Caltex Jet Fuel Pipeline Upgrade Project (11_0004)

Caltex Jet Fuel Pipeline Upgrade Project (11_0004)

WorkCover - Major Hazard Facilities Team comments on the Preliminary Hazard Analysis (PHA)

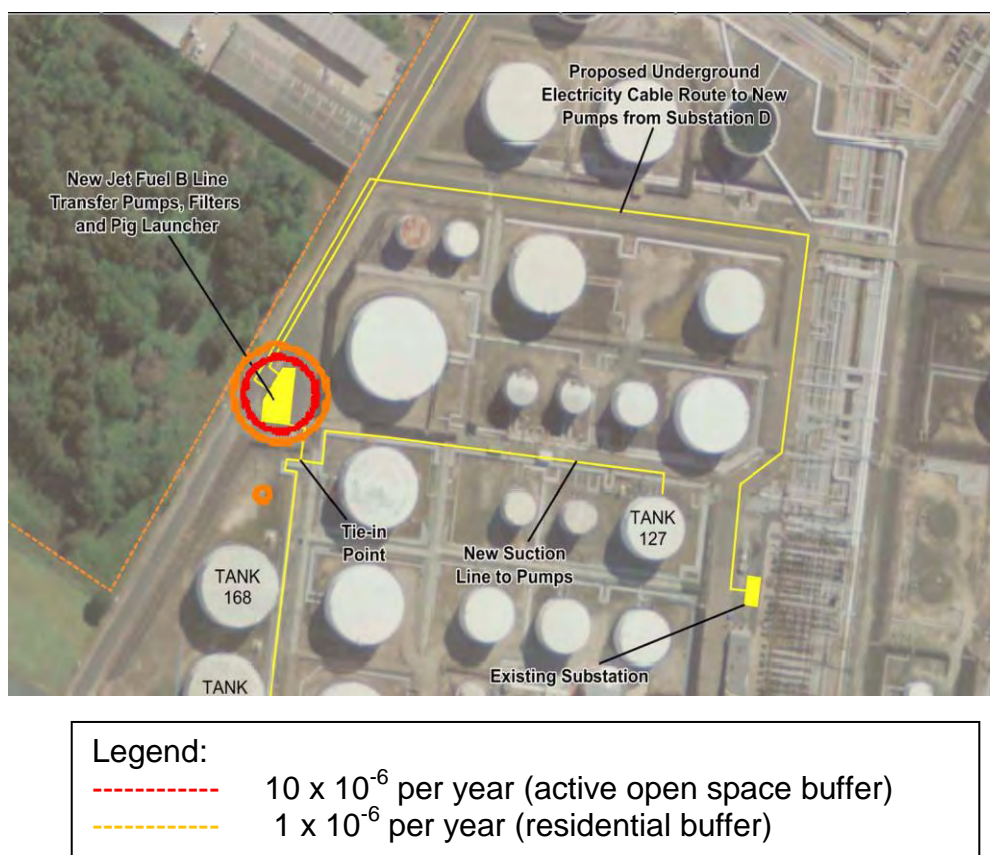
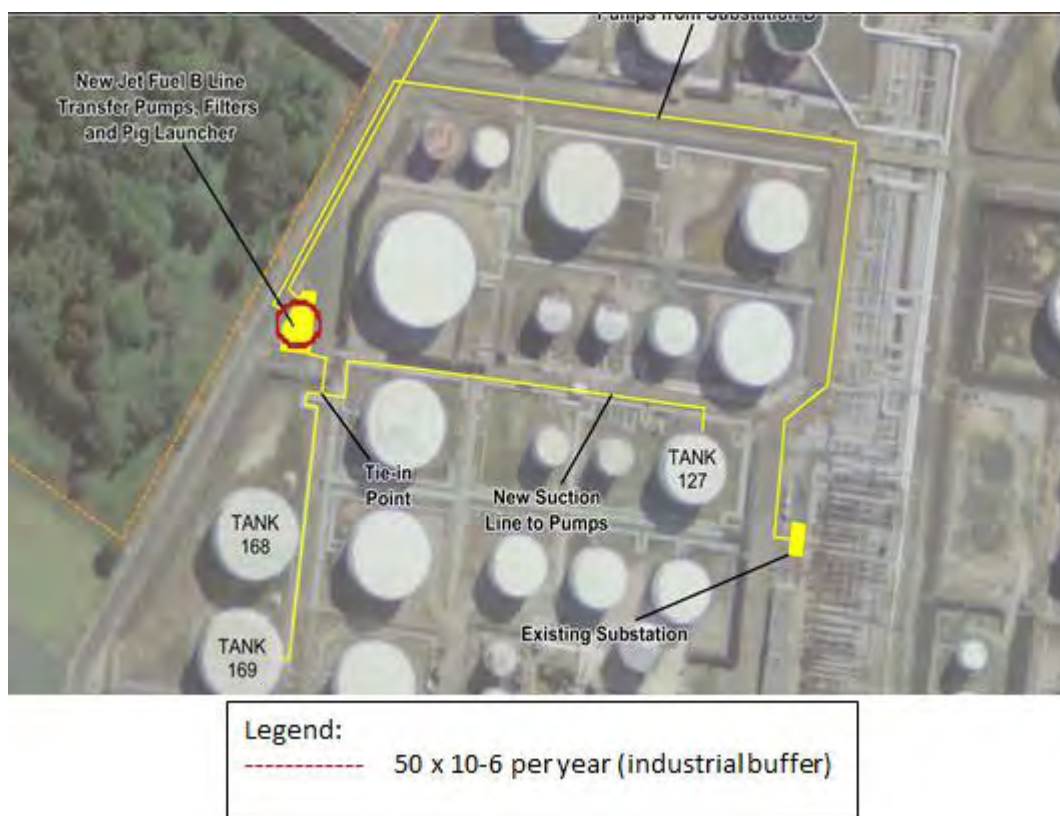
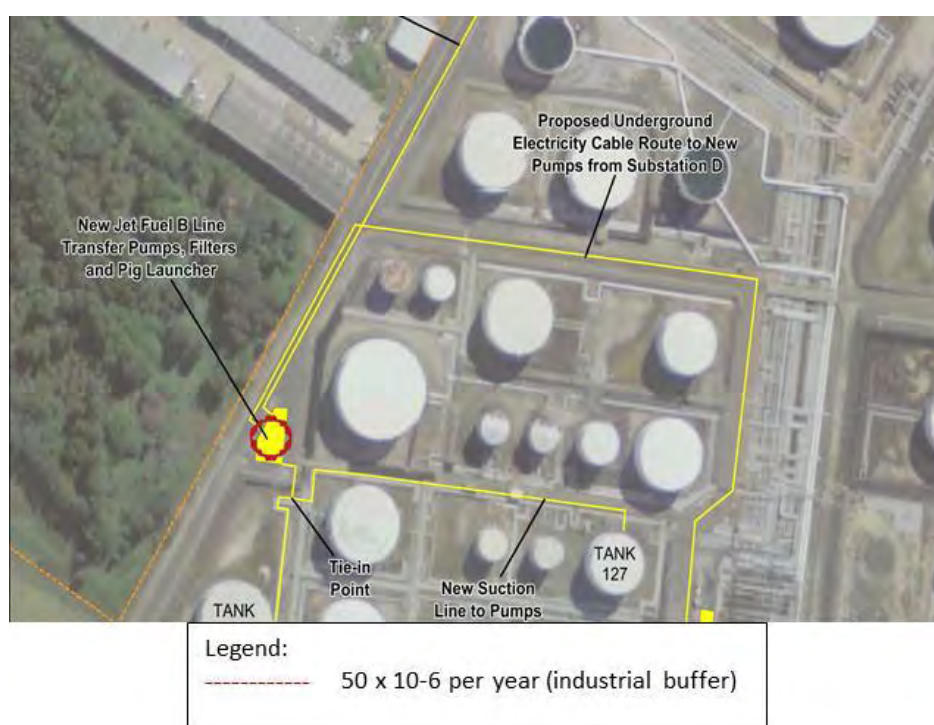
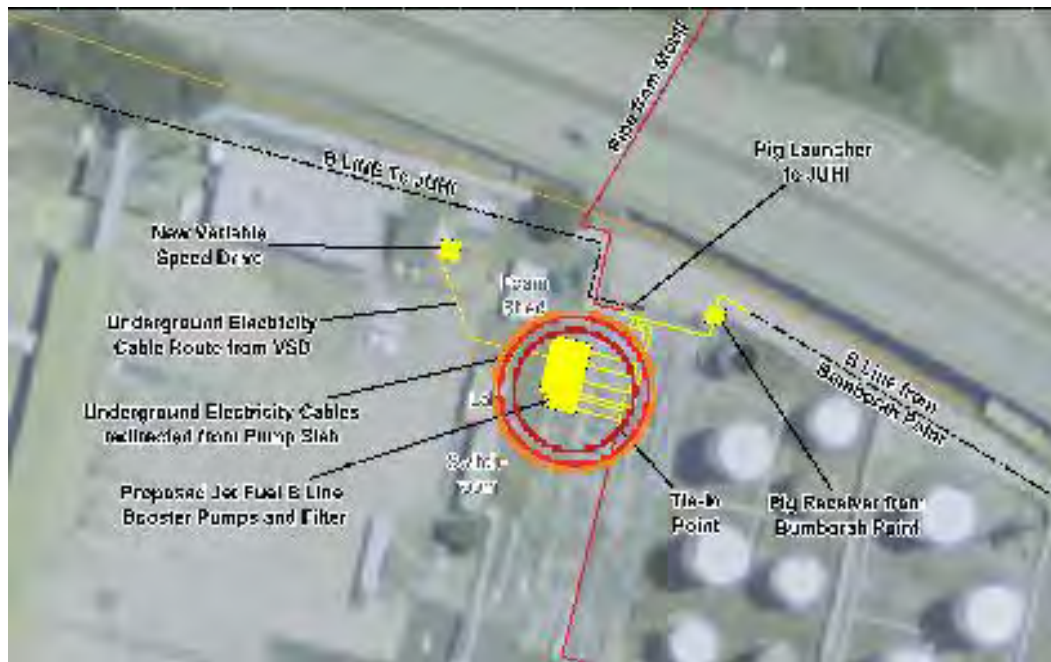
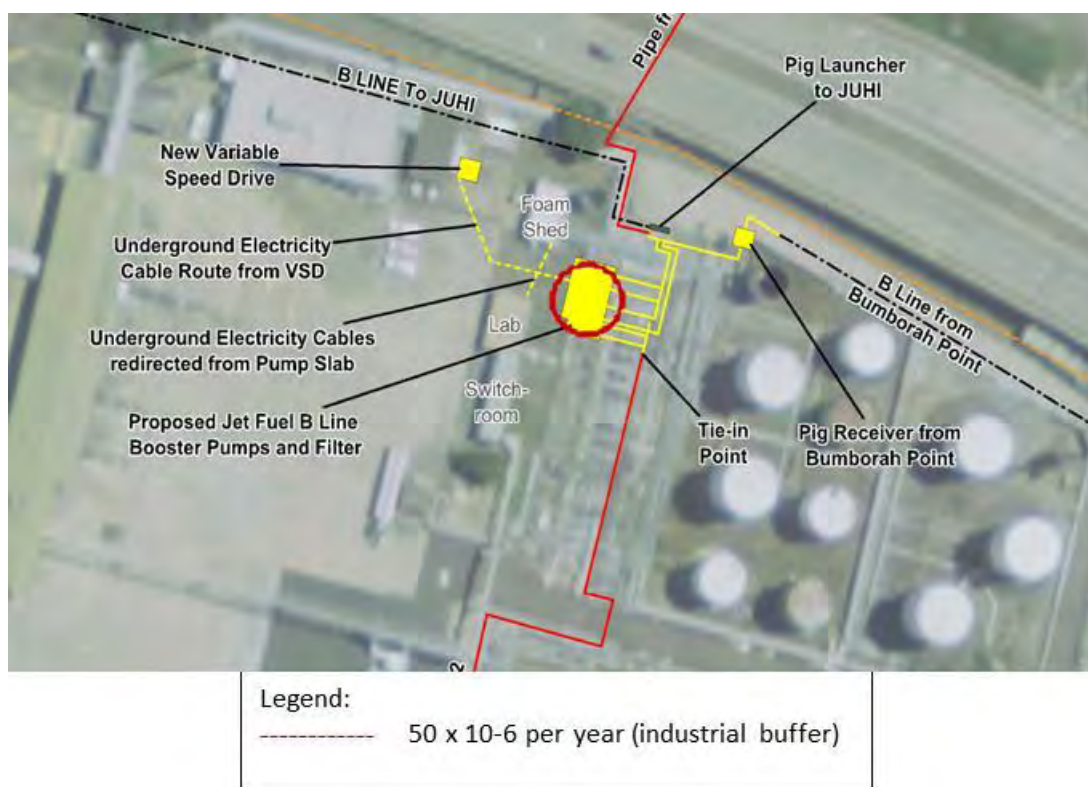
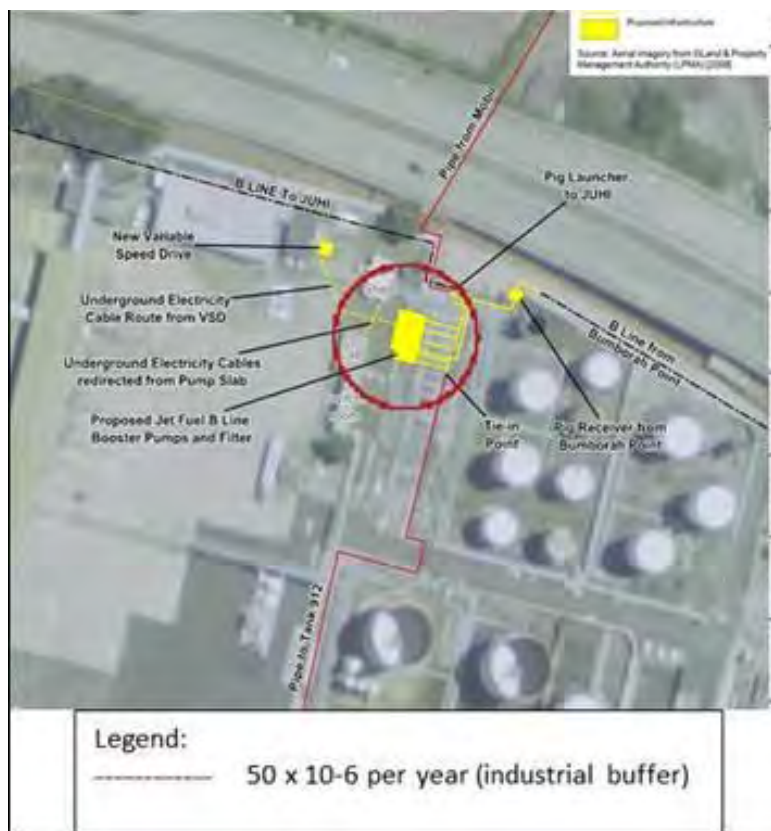
6. Table 8 Current Risk Profile, Pumping Stations and KBL Line - Dot point 2 below table 8 gives a risk reduction (scenario 5) from intermediate to low. Some detail or explanation of the before and after risks should be included here. For example, although the new location is bundled, it is in closer proximity to other plant and tanks and therefore the risk of escalation could be higher at the new location.
